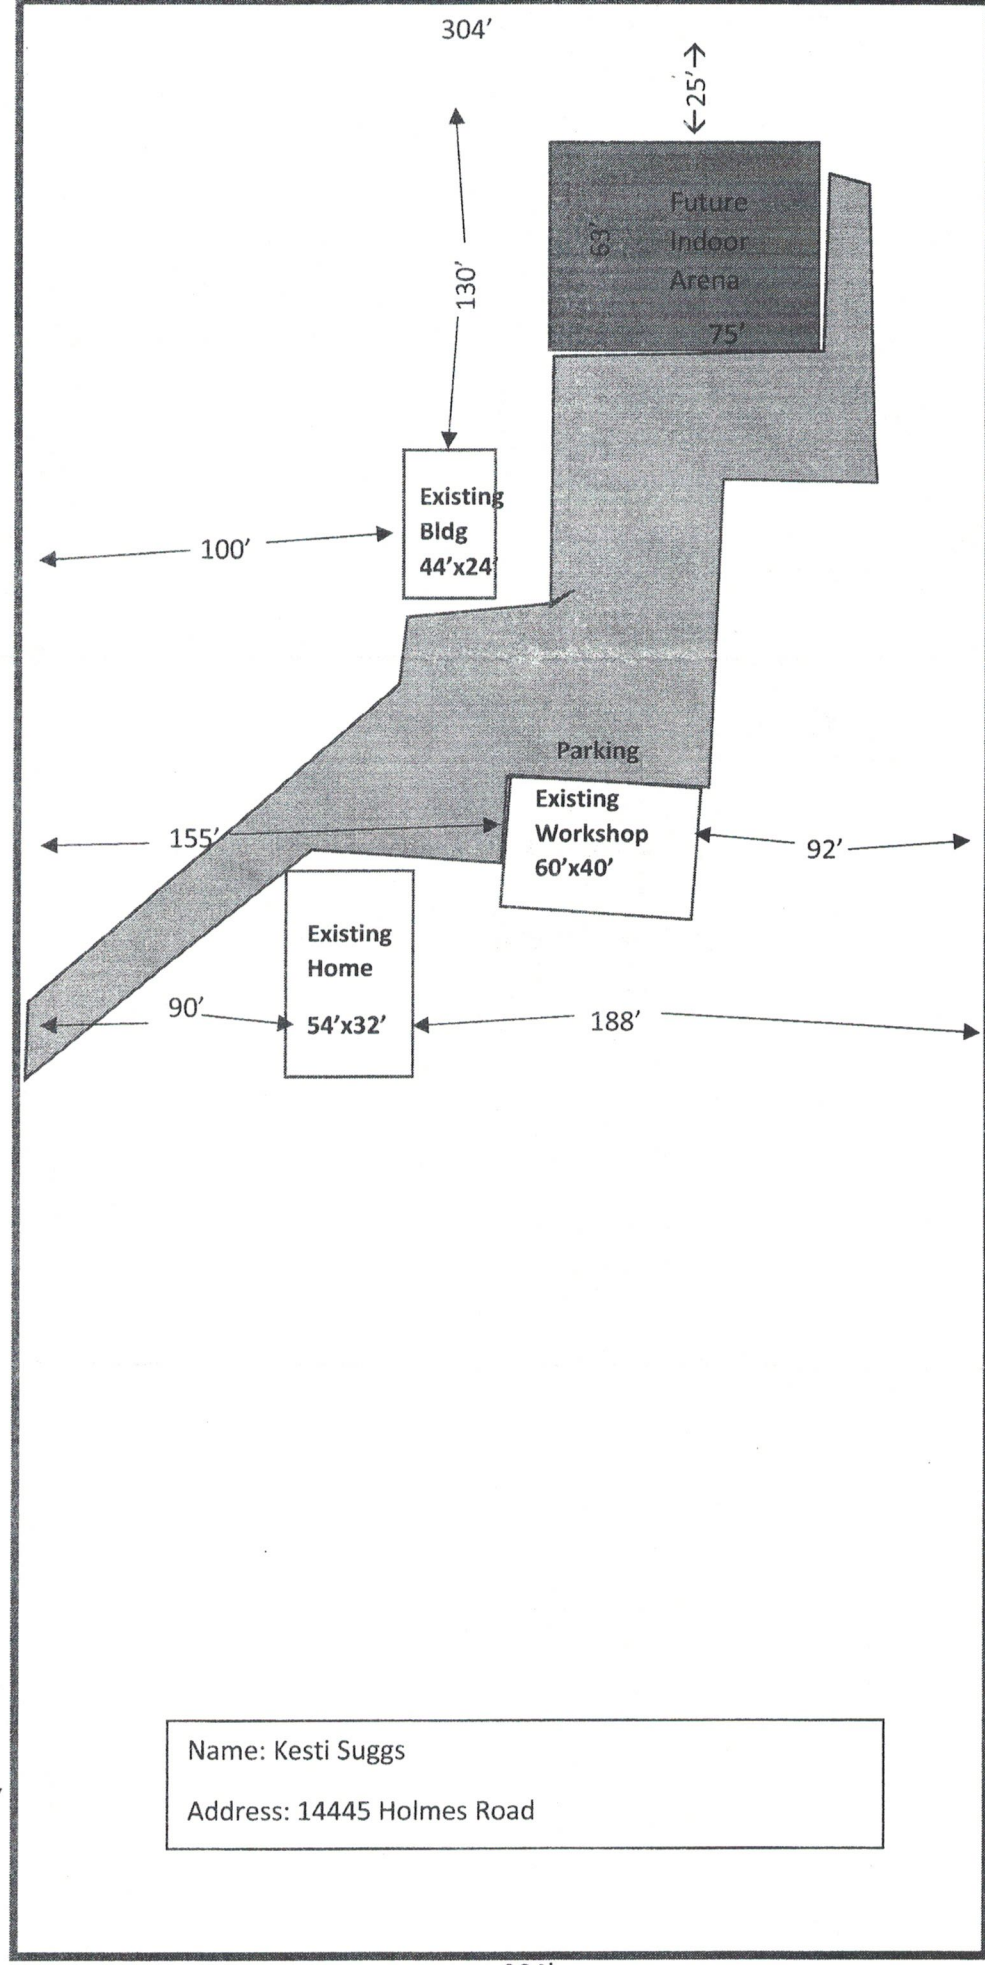
This looked close when I did a site visit, you may want to get a surveyor to show the exact boundaries and setbacks of buildings so you don't build your structure too close to the property line.

Setback?

Show all improvements on the property including horse stalls and riding trails/ areas for the horses.

Show all improvements on the property including horse stalls and riding trails/ areas for the horses.

There should be a structure here.

There should be a structure here.

There should be a structure here.

There should be a structure here.

This looked close when I did a site visit, you may want to get a surveyor to show the exact boundaries and setbacks of buildings so you don't build your structure too close to the property line.

See checklist for other items to put on this plan.
